RESPONSE TO PLANNING COMMENTS INCLUDING CALCULATIONS – Rev. E

SIMPLY UK

HOOK ROAD, PAGHAM

CS&P REF: 9418

TYPICAL SECTION ALONG ATTENUATION SYSTEM (REFER TO DRAWING C016)

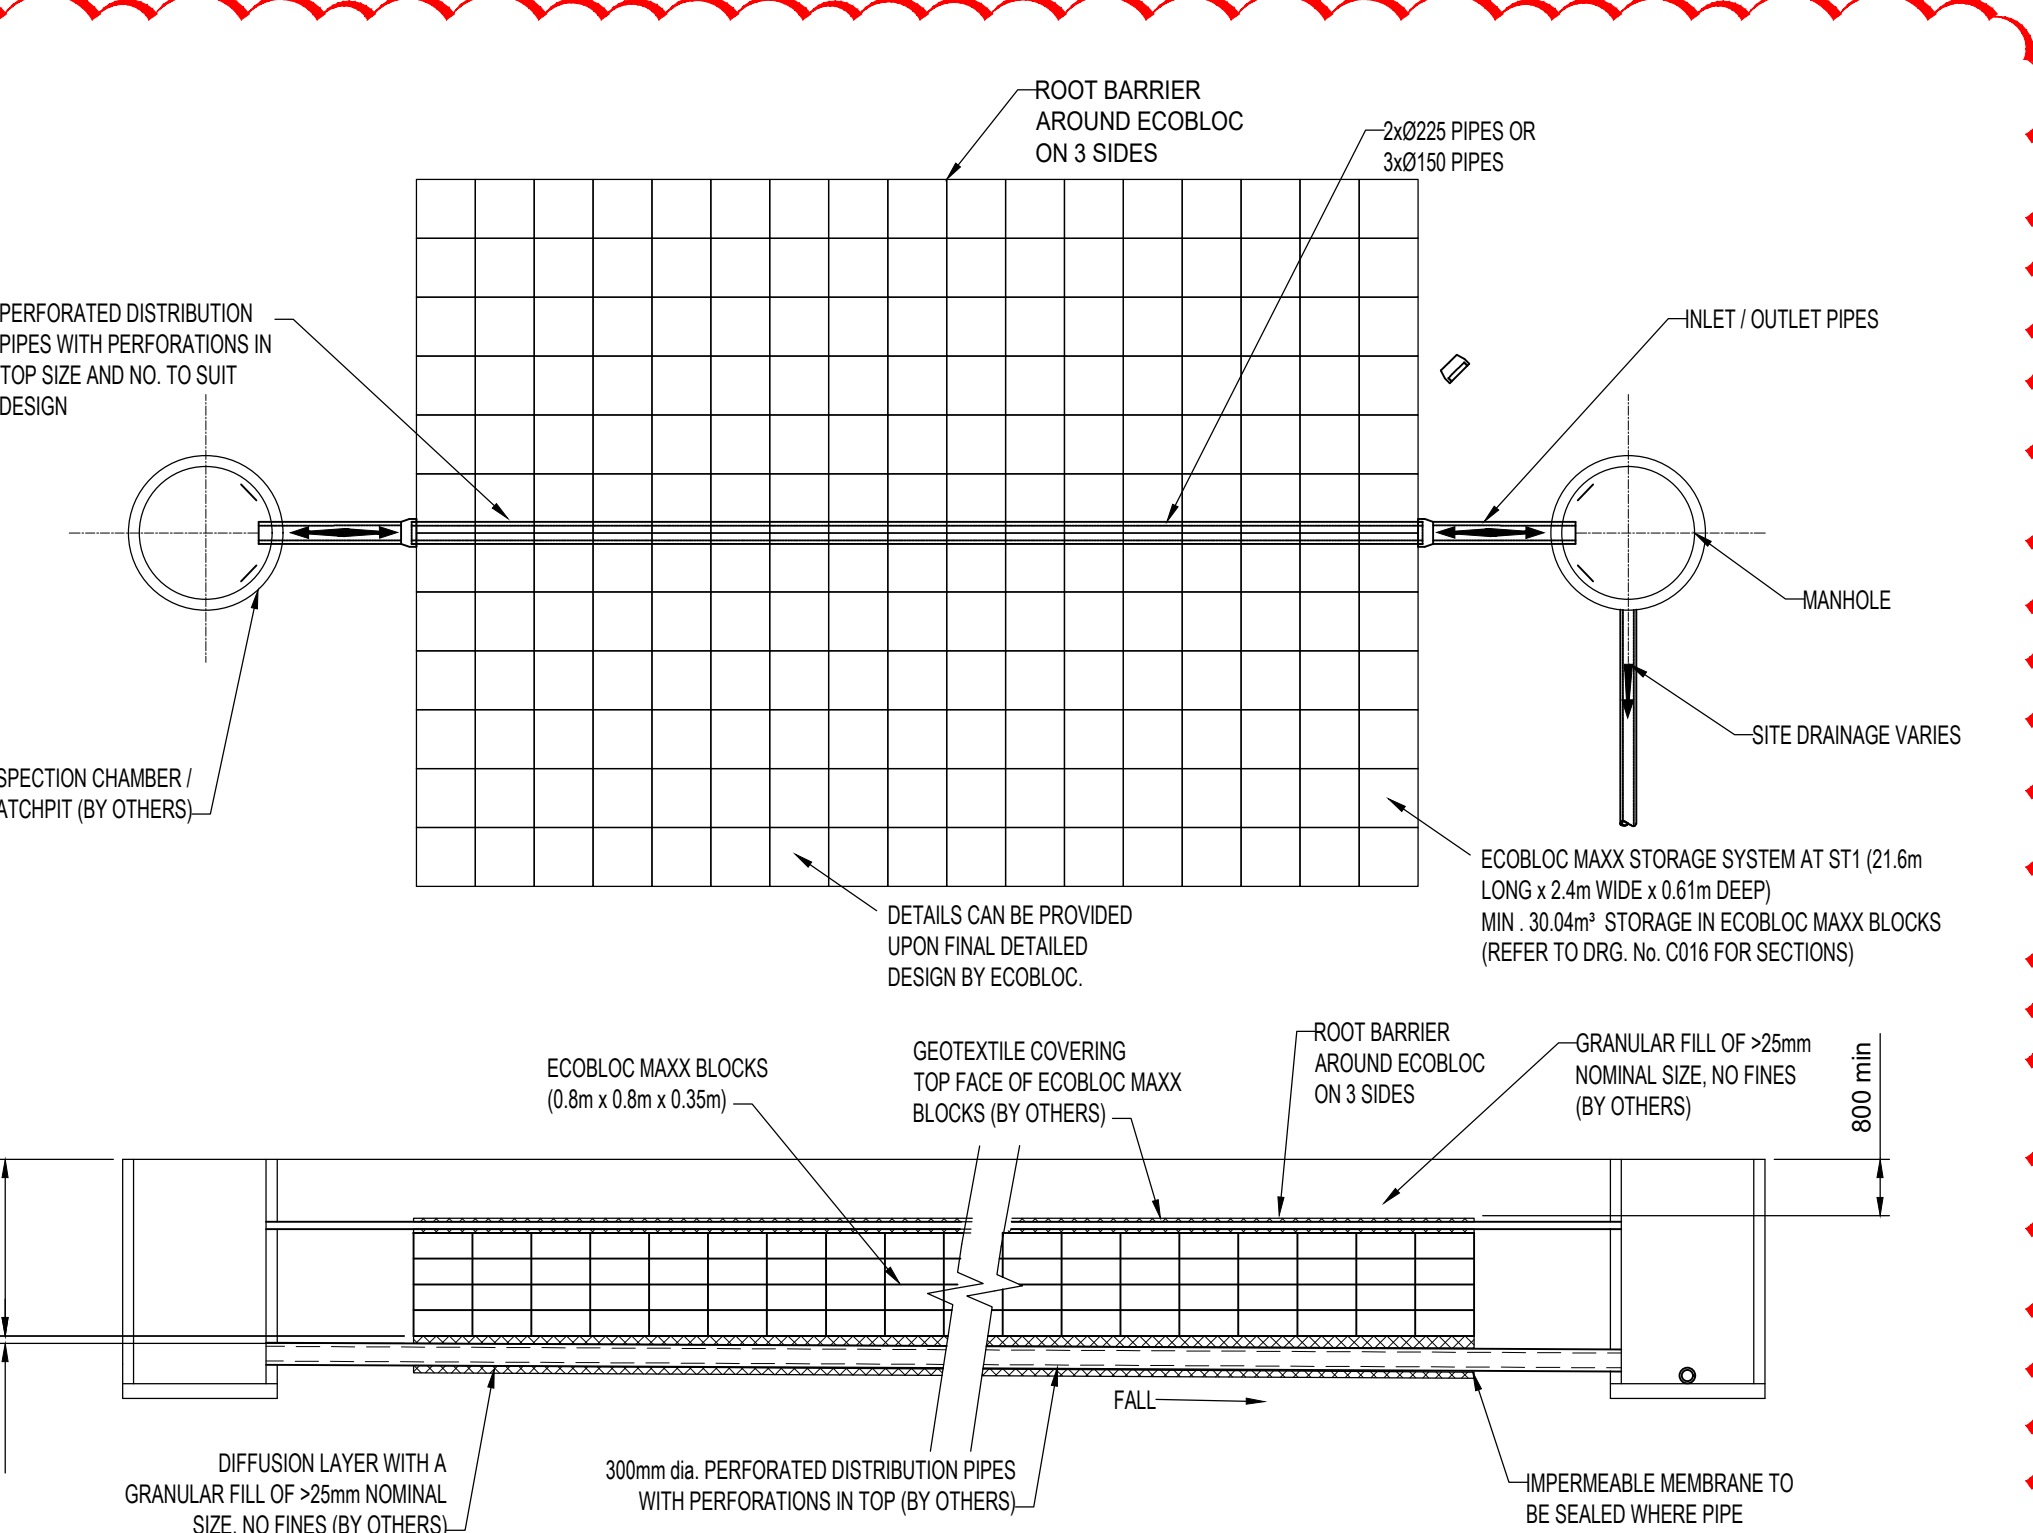
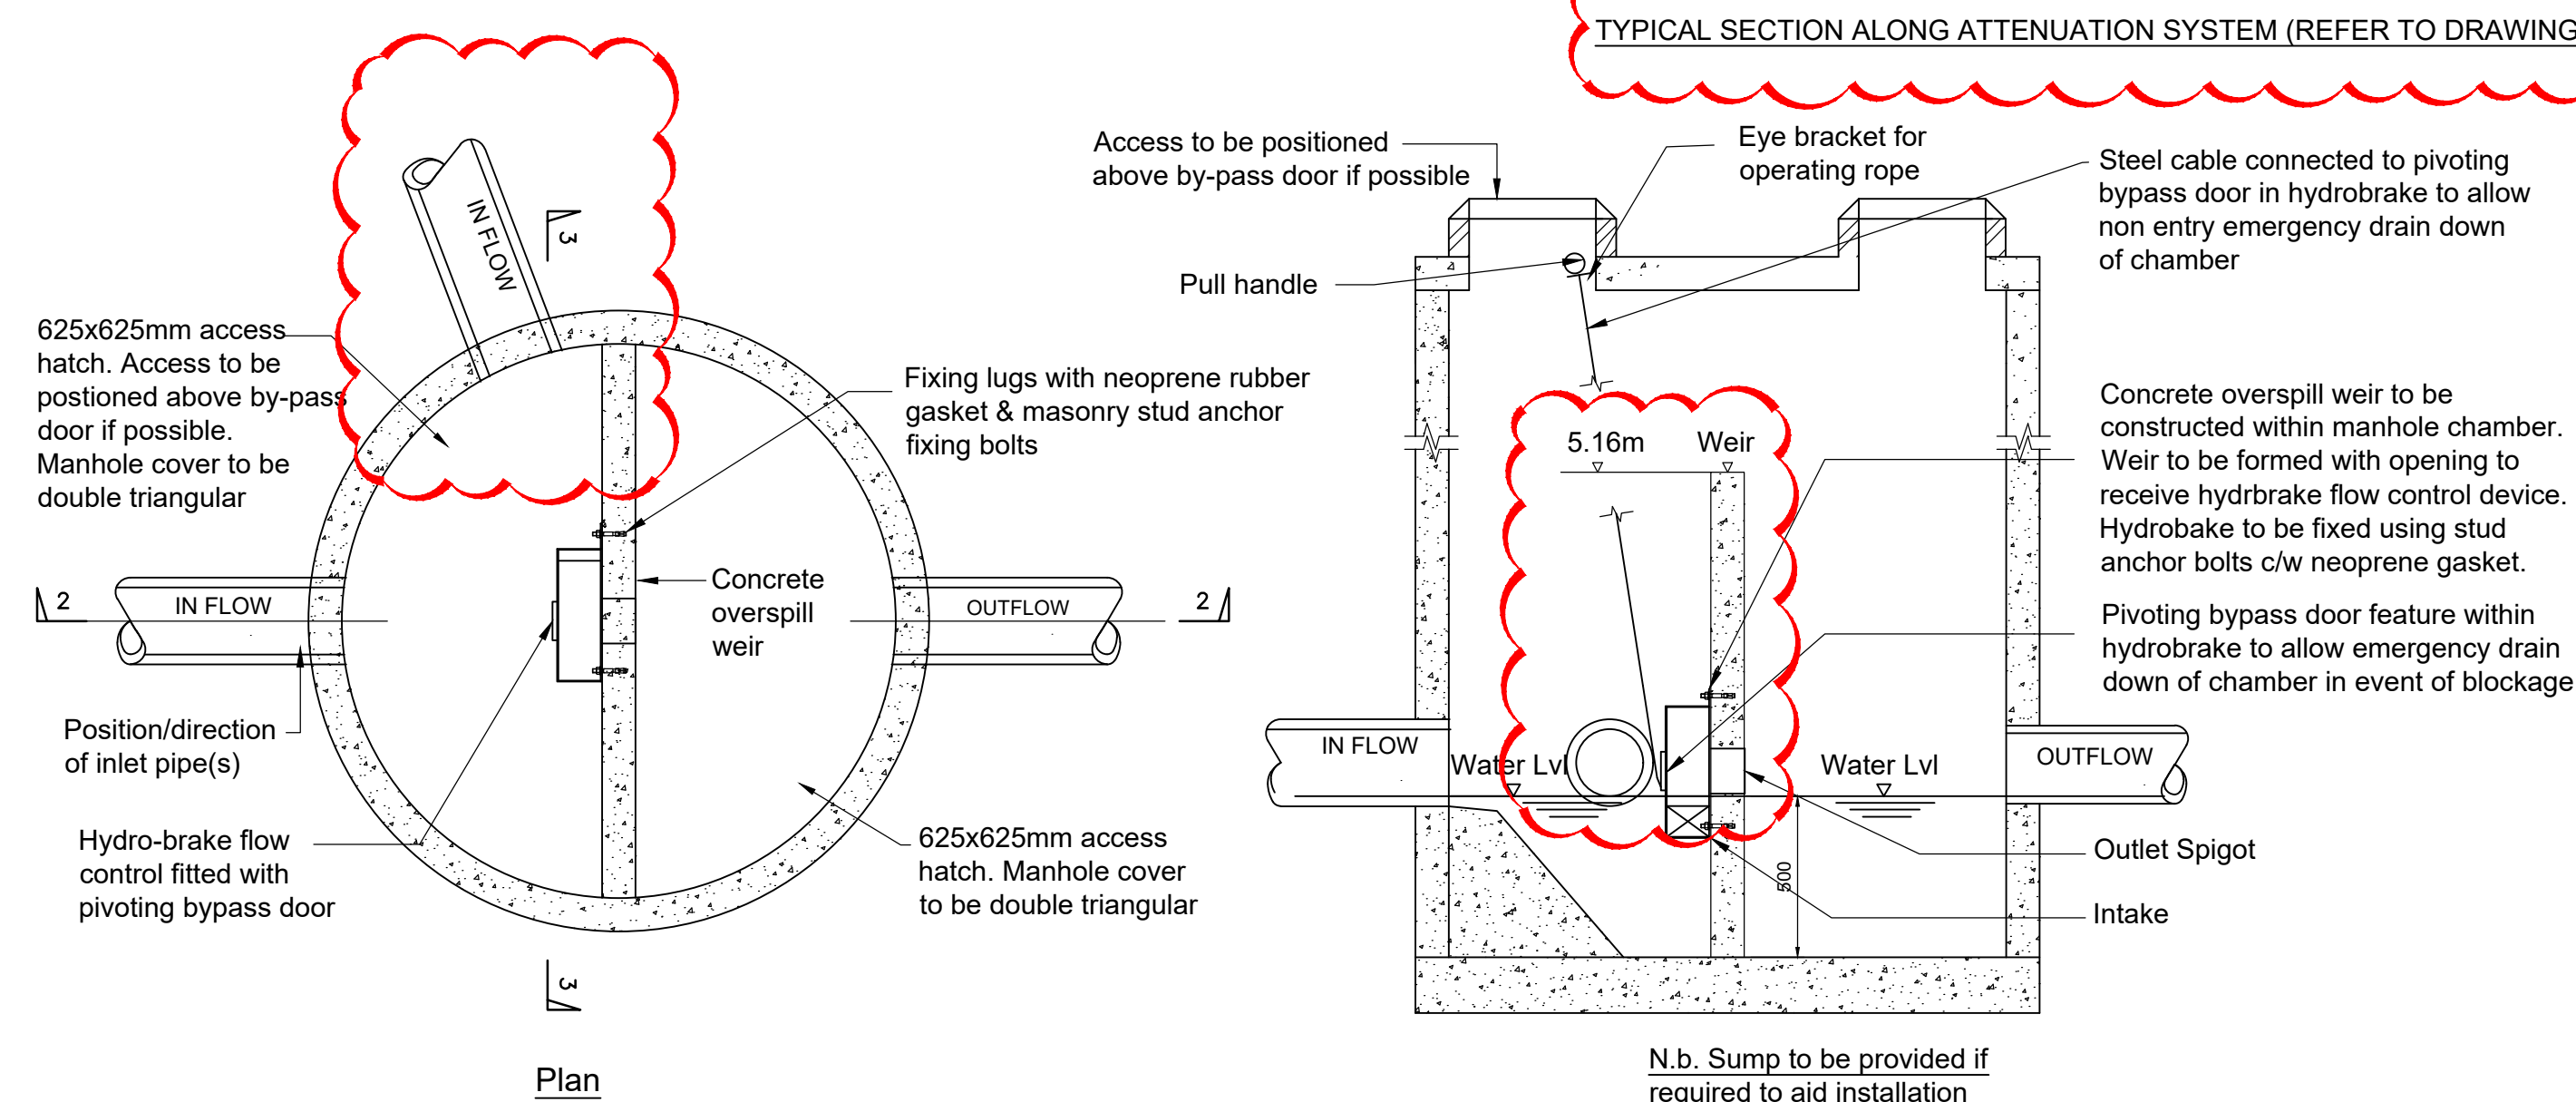
A. The tank detail on drawing 9418-C003-H still indicates conflicting information. The plan section indicates 2x 225mmdia. Or 3x150mm dia pipes whilst the section indicates a 300mm perforated distribution pipe.

A & E - We have provided revised drawings in Appendix F.

ST1
(CLOSEST LOCATION TO TREES)
SCALE 1:20

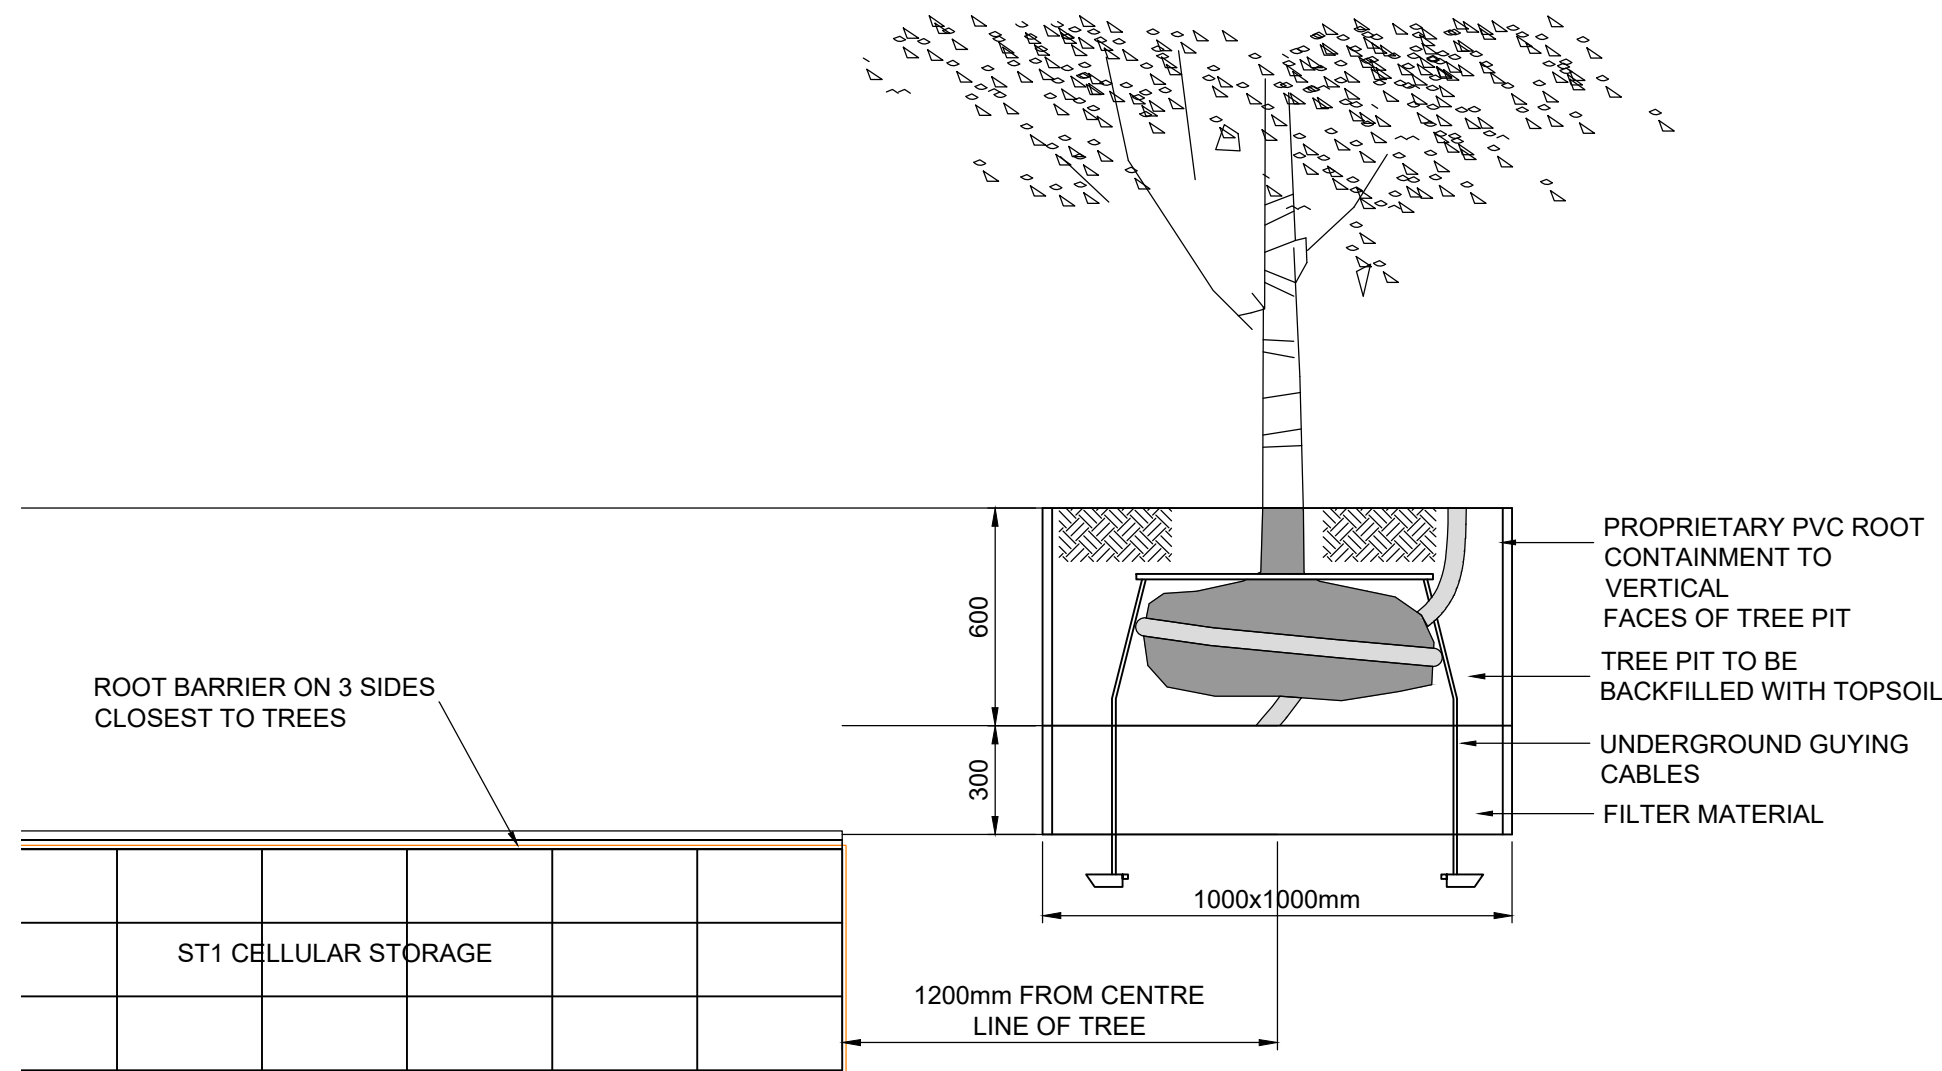
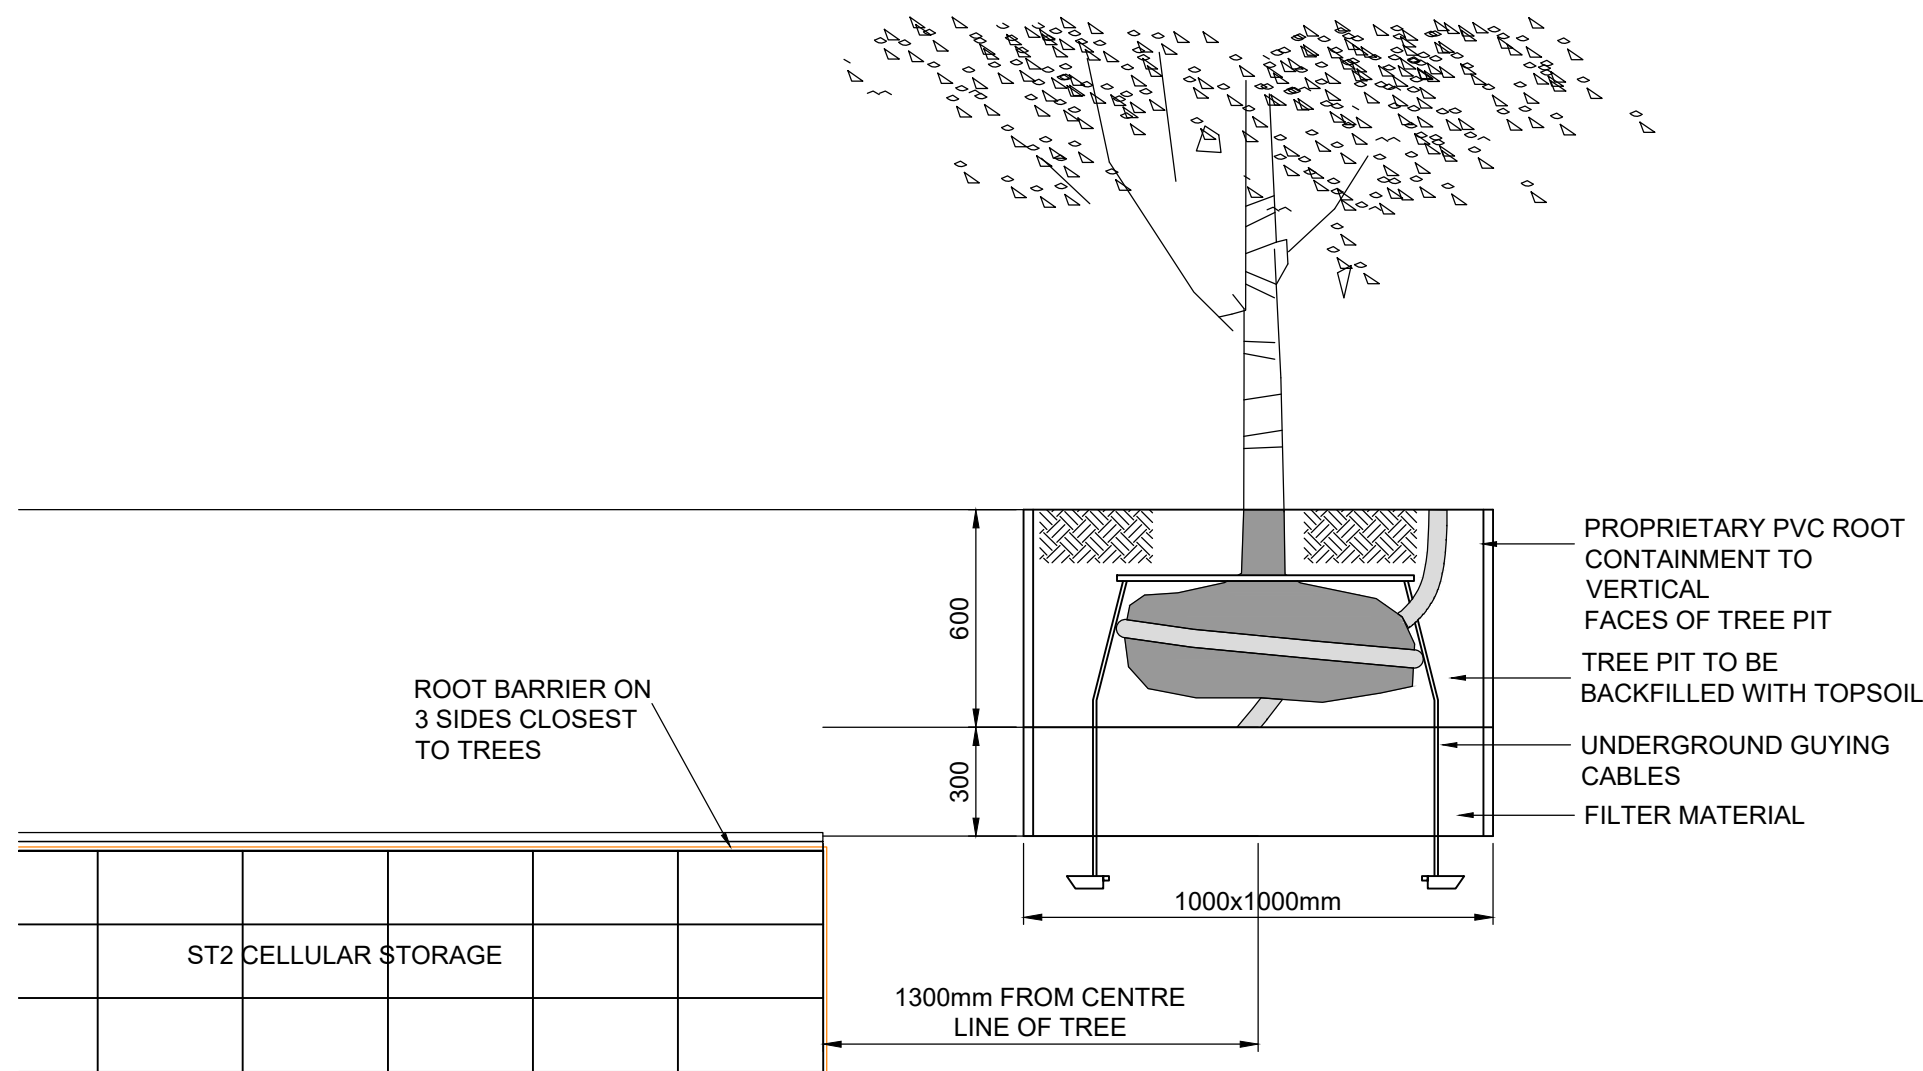
G. (New Item - there appears to be clashes on the proposed drainage runs and trees SW-IC03.01 to SW-MH-02.01 and SWIC-01.03 to SW-IC01.04.

We have provided revised drainage drawings in Appendix F to ensure no clashes with trees. See Appendix F for details.
